Addendum #1

**The Parkside Neighborhood Center
and Affordable Housing
Mellen & Grant Streets,
Portland, Maine 04101**

February 12, 2004

7 WC, ROOM # 203
1/4" = 1'-0"

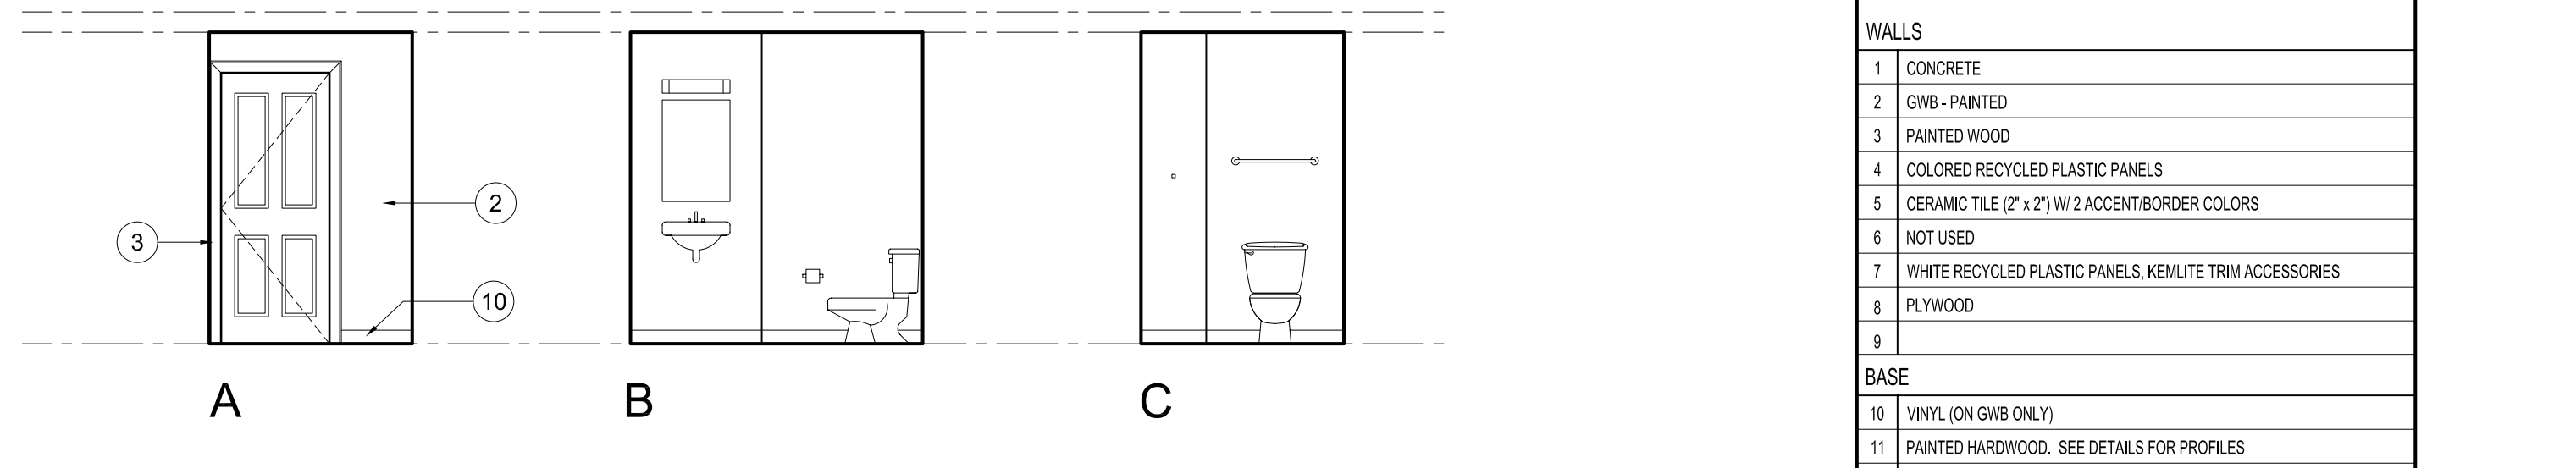
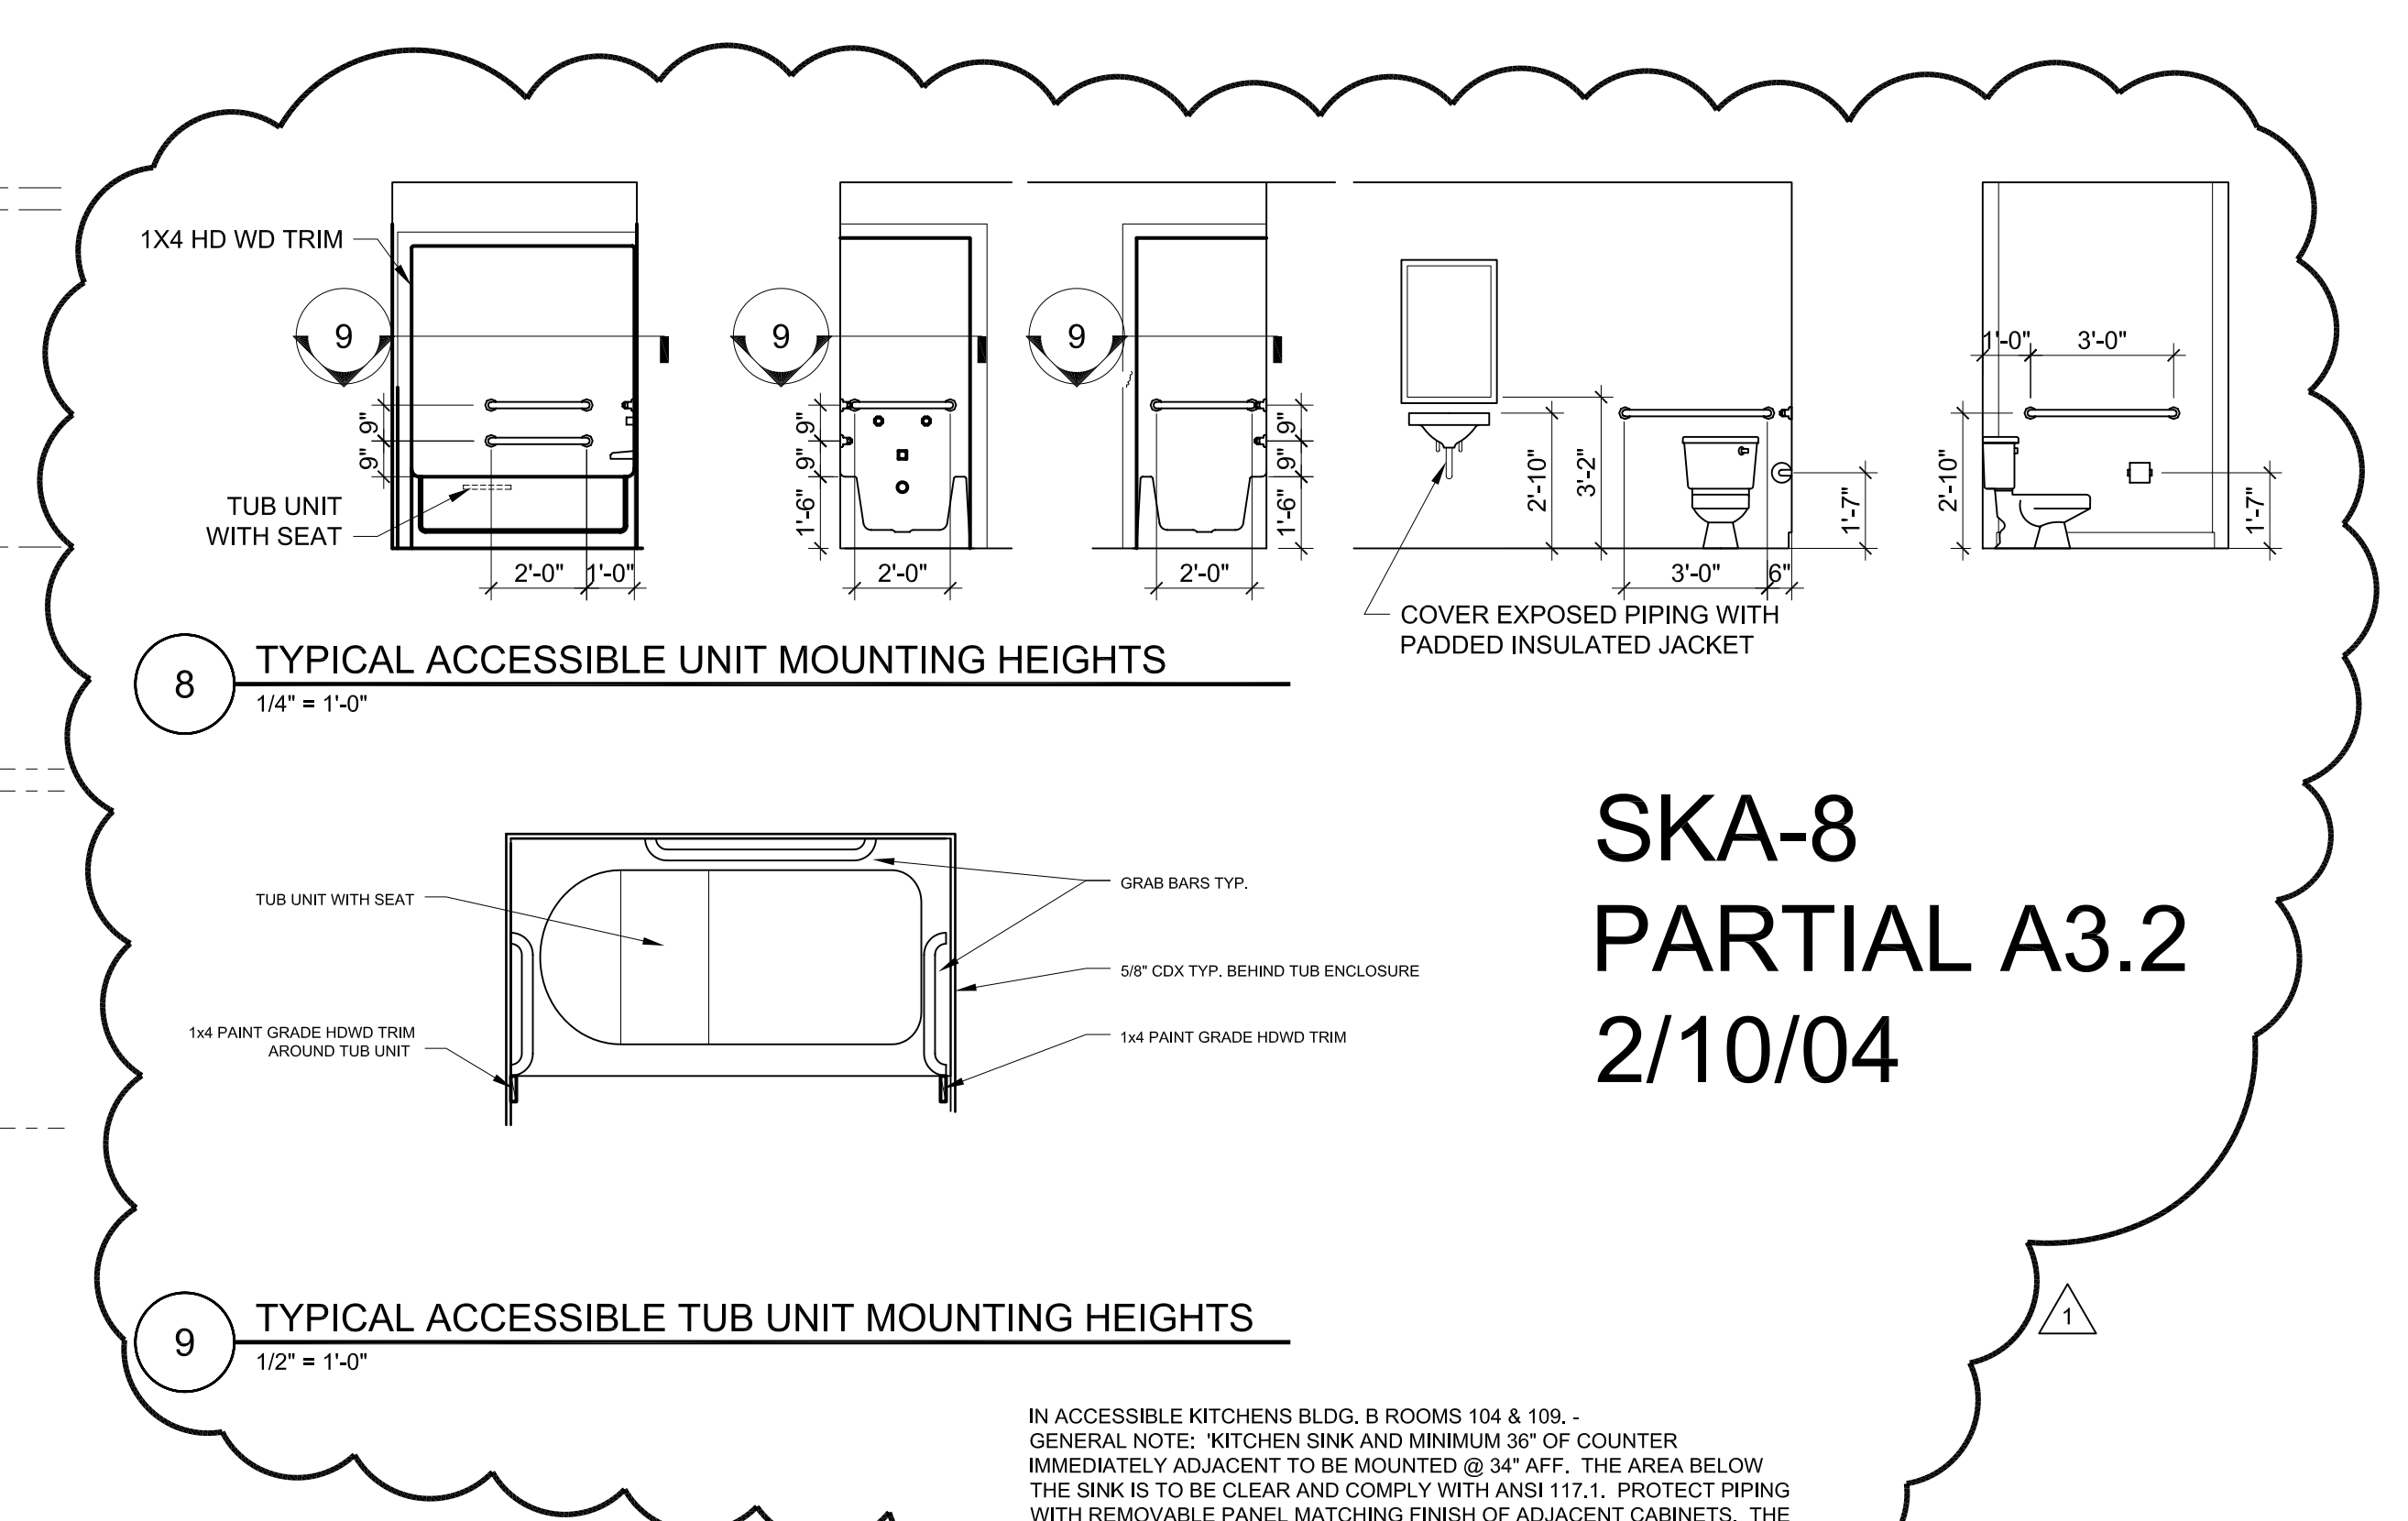
Typical residence unit interior elevations are shown on Sheet A3.2 Bldg A. These are intended to cover the range of interior conditions for all units in Buildings A & B. Unique conditions are called out in respective plans and reflected ceiling plans or similar interior elevations as required. Sub contractors are to coordinate plans, reflected ceiling plans, schedules and typical unit elevations for the appropriate scope of work.

BUILDING B
S3.0

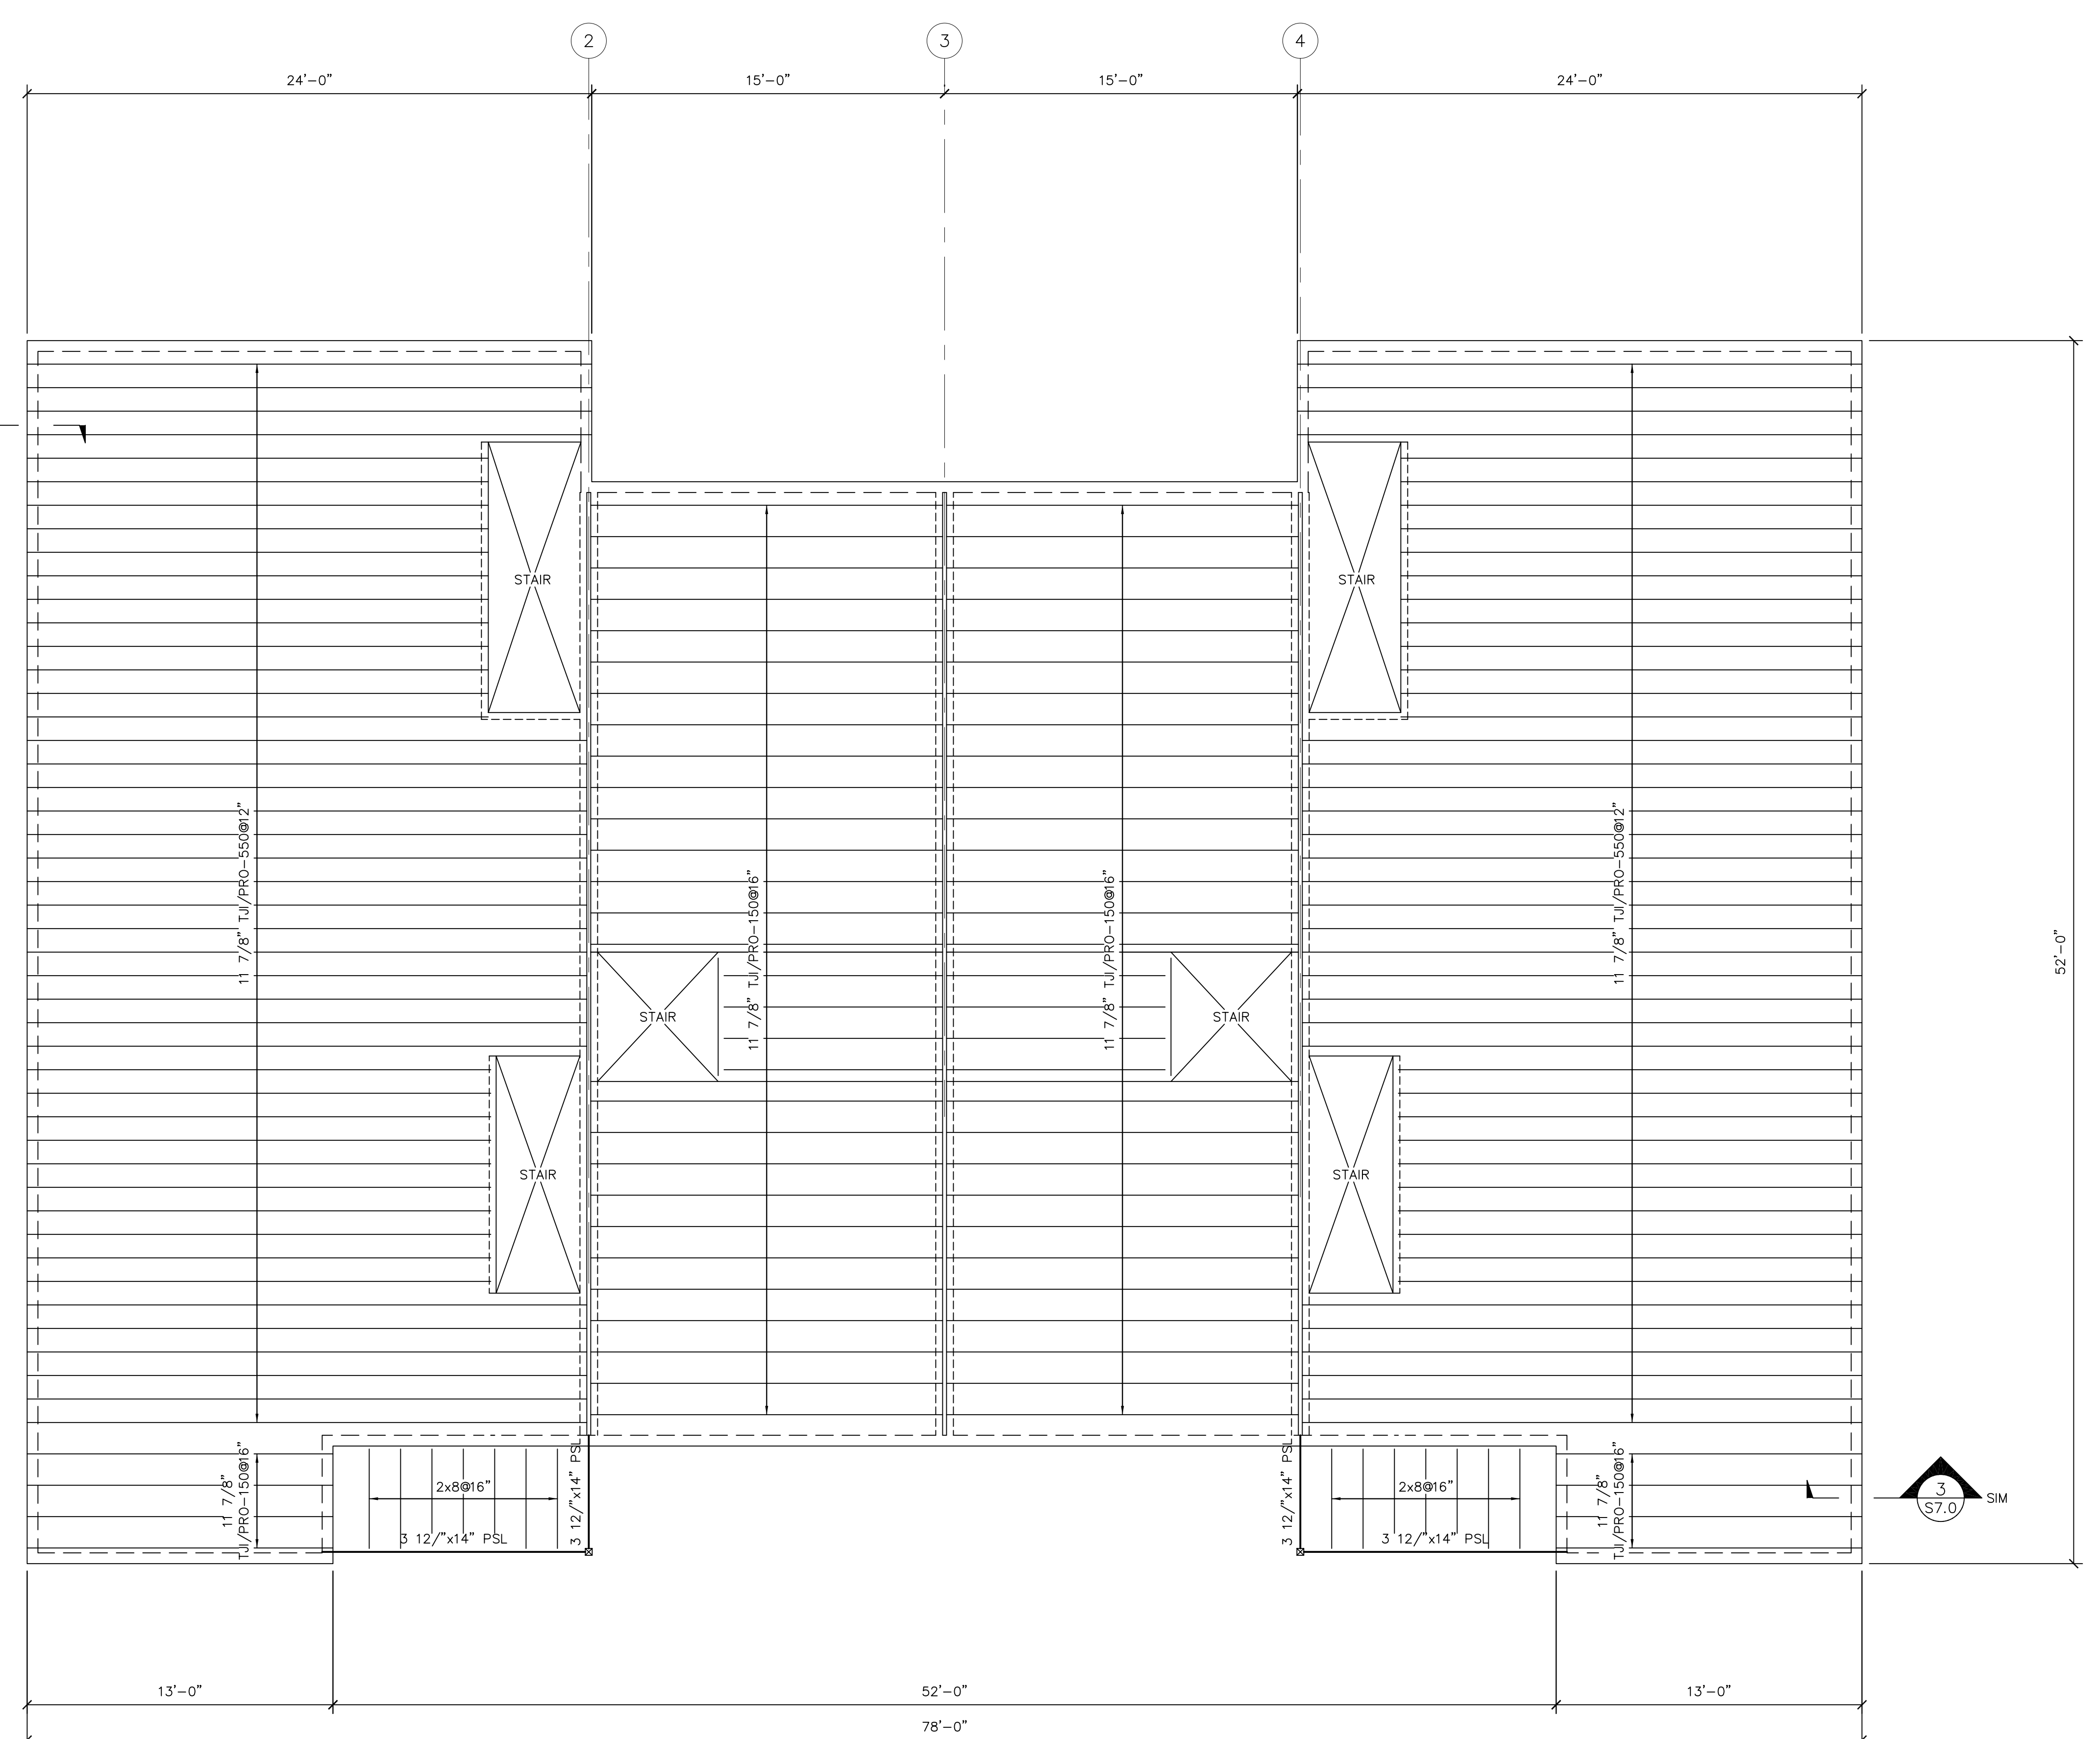
- 1-64 S0.1 Bldg A/B INSERT Joist Hanger Schedule per SK6.
- 1-65 S1.0 Bldg A Revise footing elevations and step locations per SK1.
- 1-66 S1.0 Bldg B Add footings and foundation walls for porches per SK2.
- 1-67 S1.0 Bldg B Add chimney footing per SK3.
- 1-68 S3.0 Bldg B Add porch framing per SK4.
- 1-69 S7.0 Bldg A/B INSERT Section 9 per SK5
